November 28, 2022

Project No. 21500820

SECOND ADDENDUM TO THE SCOPED ENVIRONMENTAL IMPACT ASSESSMENT FOR THE PROPOSED DEVELOPMENT OF 30 FRANK NIGHBOR PLACE, OTTAWA, ONTARIO

**1 BLDG D - "WT" (TRUE) - ELEVATION**  
 1/4" = 1'-0"

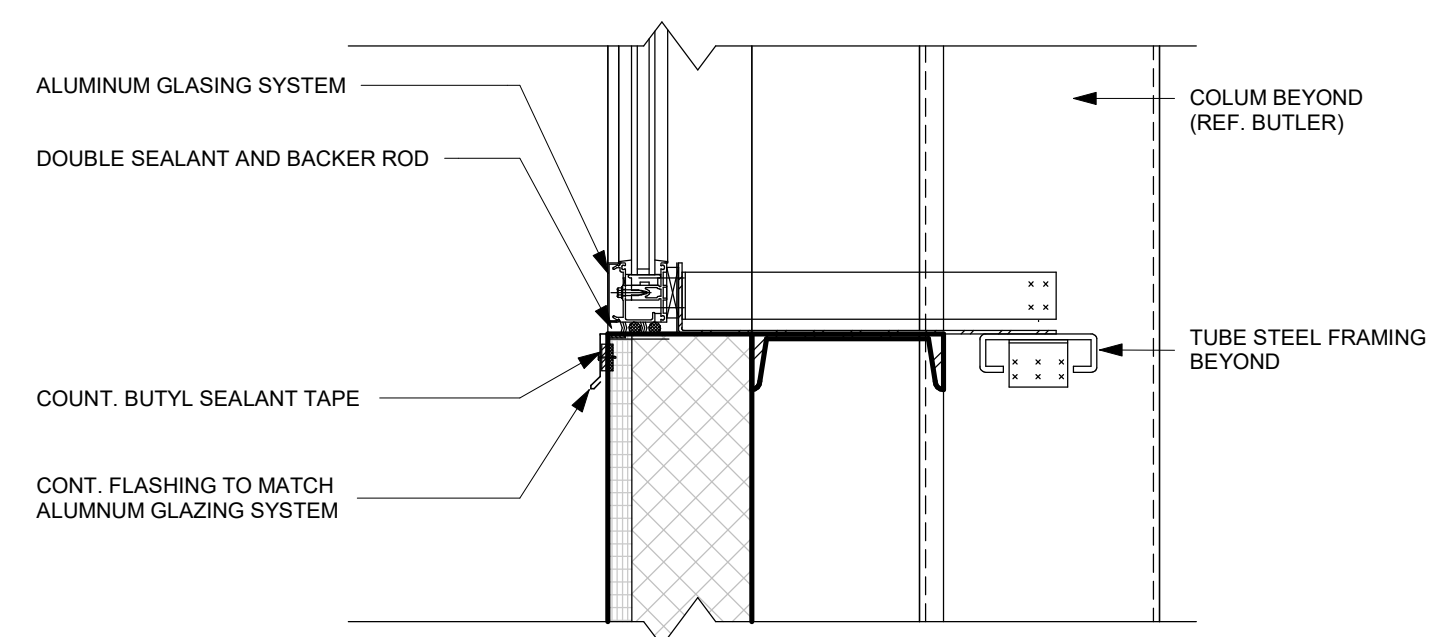
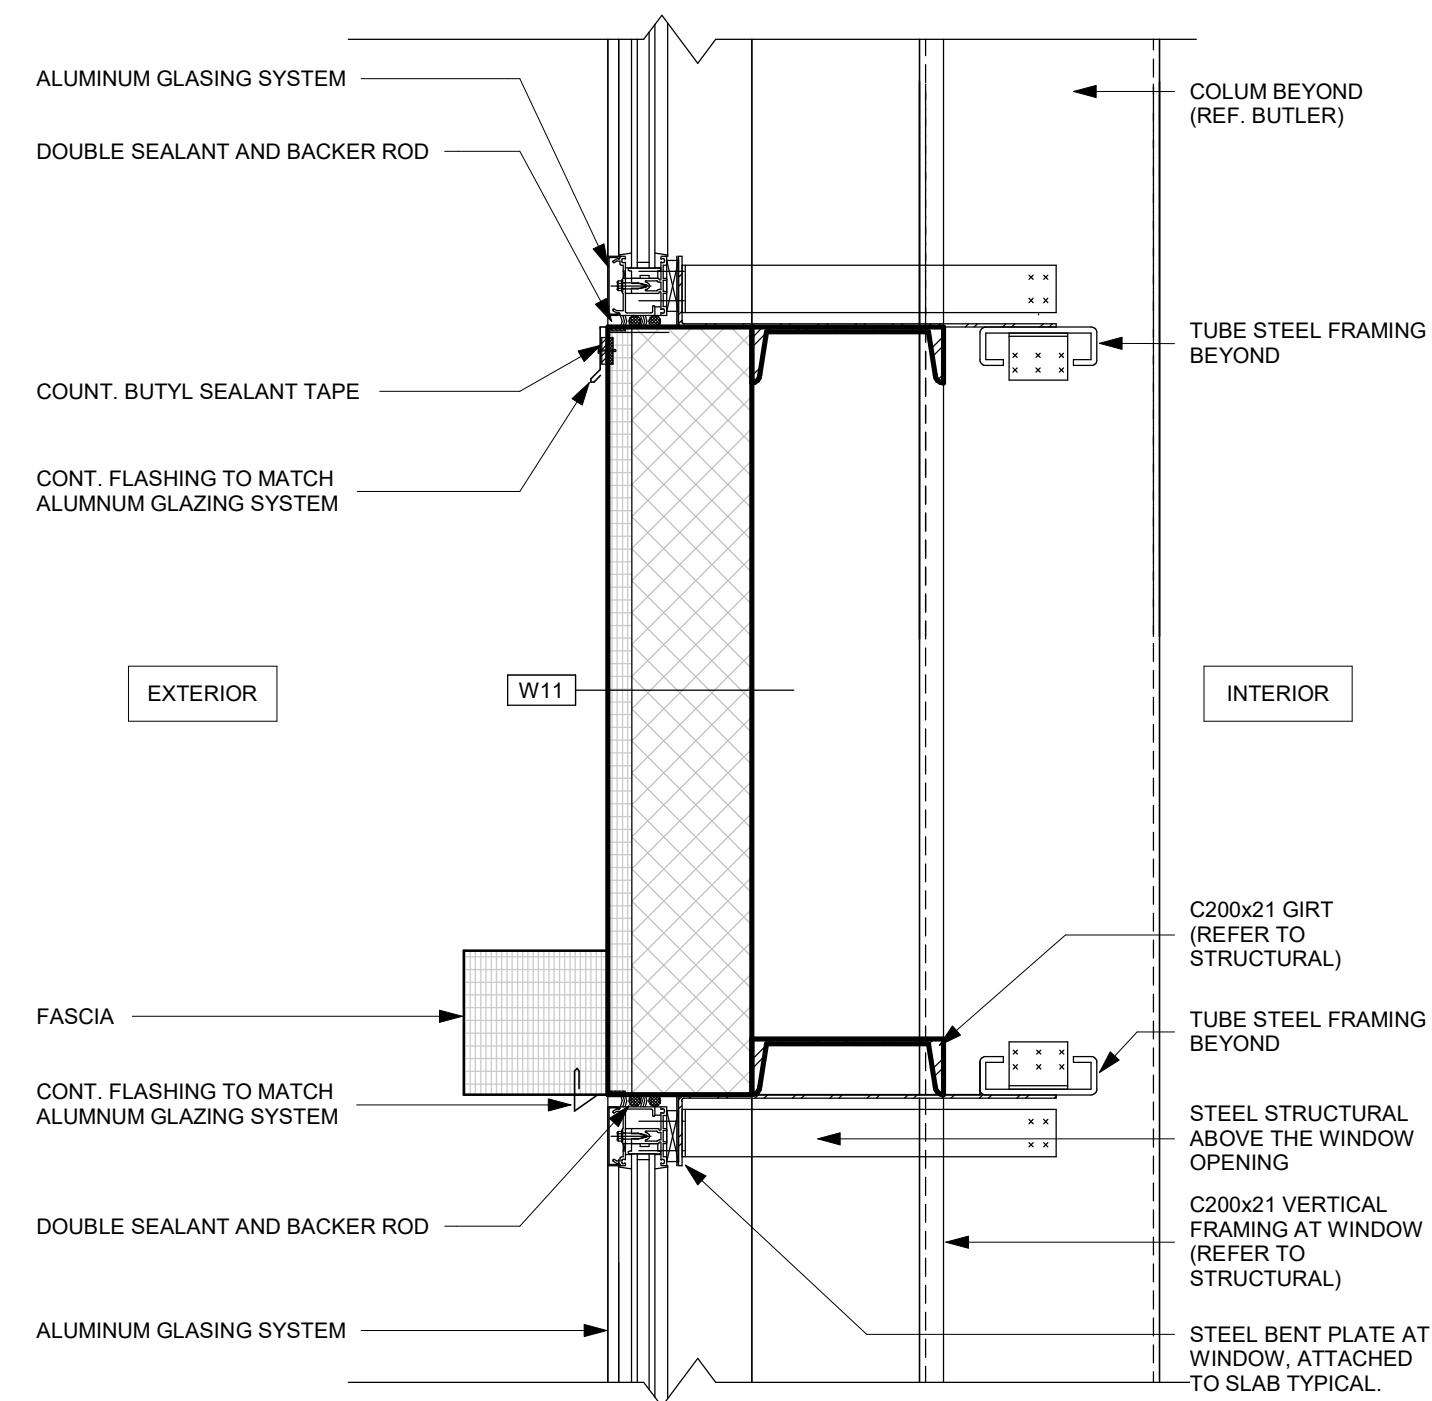
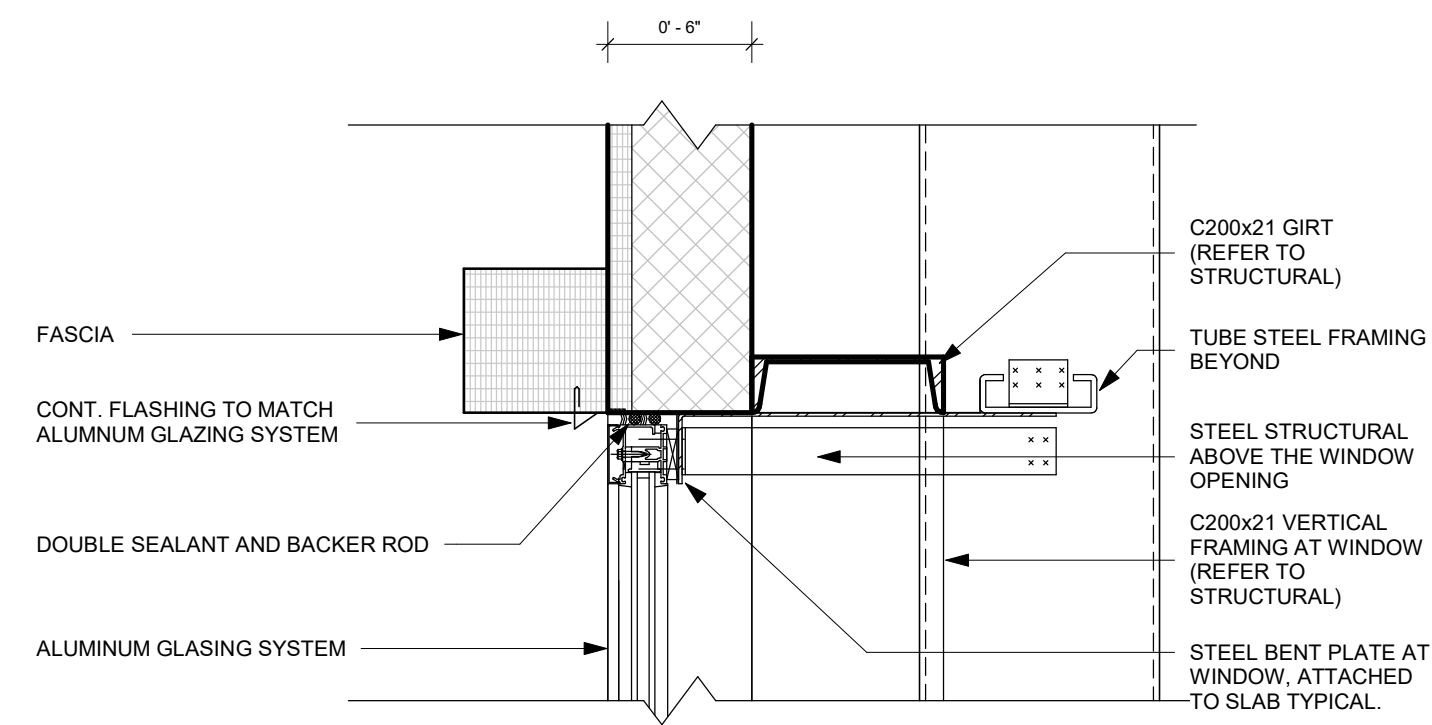
- Include plantings of native trees along the western edge of the Site along the Carp River corridor; and,
- Incorporate elements from the City of Ottawa's Bird-Safe Design Guidelines (Ottawa 2020) into the proposed building design.

IBI Group has added window frit design to the Site Plan and Elevations (IBI Group November 16, 2022) in accordance with the City of Ottawa's Bird-Safe Design Guidelines (Ottawa 2020). Please refer to the revised Site Plan and Elevations prepared by IBI Group dated November 16, 2022 for more details.

DRAWING NAME
LANDSCAPE PLAN

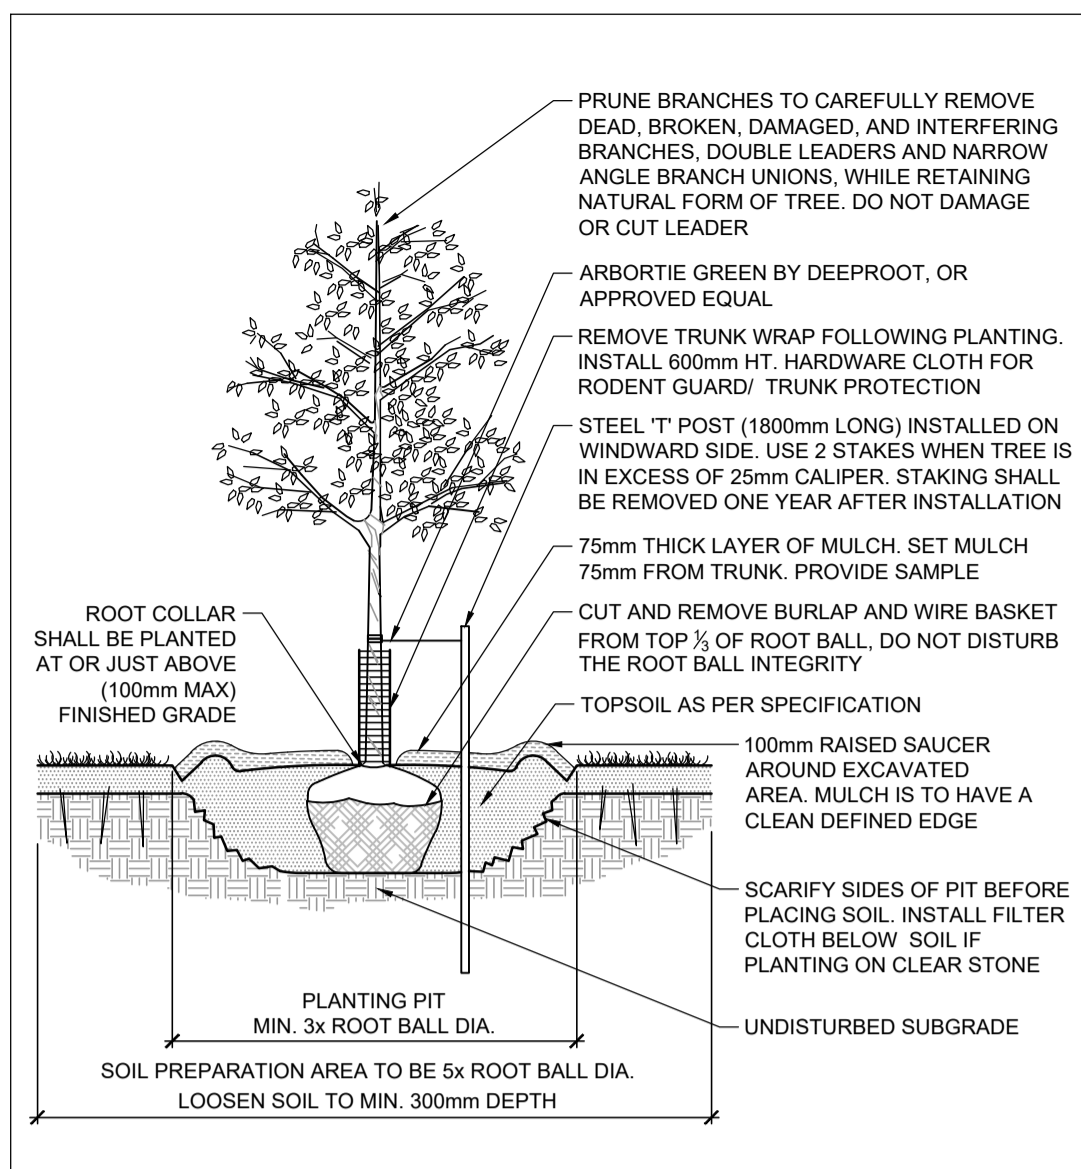
Following the submission of the EIS addendum, the City of Ottawa had two remaining natural environment comments that necessitated edits to the proposed project (per email from Sami Rehman dated October 12, 2022), namely:

To address these remaining comments, the Landscape Plan (Novatech November 14, 2022) for the proposed development has been revised by Novatech to incorporate the suggested mix of native species along the western property boundary abutting the Carp River as recommended. An additional nine (9) plantings are proposed and include three (3) silver maples (*Acer saccharinum*), three (3) red maples (*Acer rubrum*), two (2) eastern white pine (*Pinus strobus*), and one (1) burr oak (*Quercus macrocarpa*). Please refer to the revised Landscape Plan Drawings No.: 121326-L1 and 121326-L2 prepared by Novatech dated November 14, 2022 for more details.
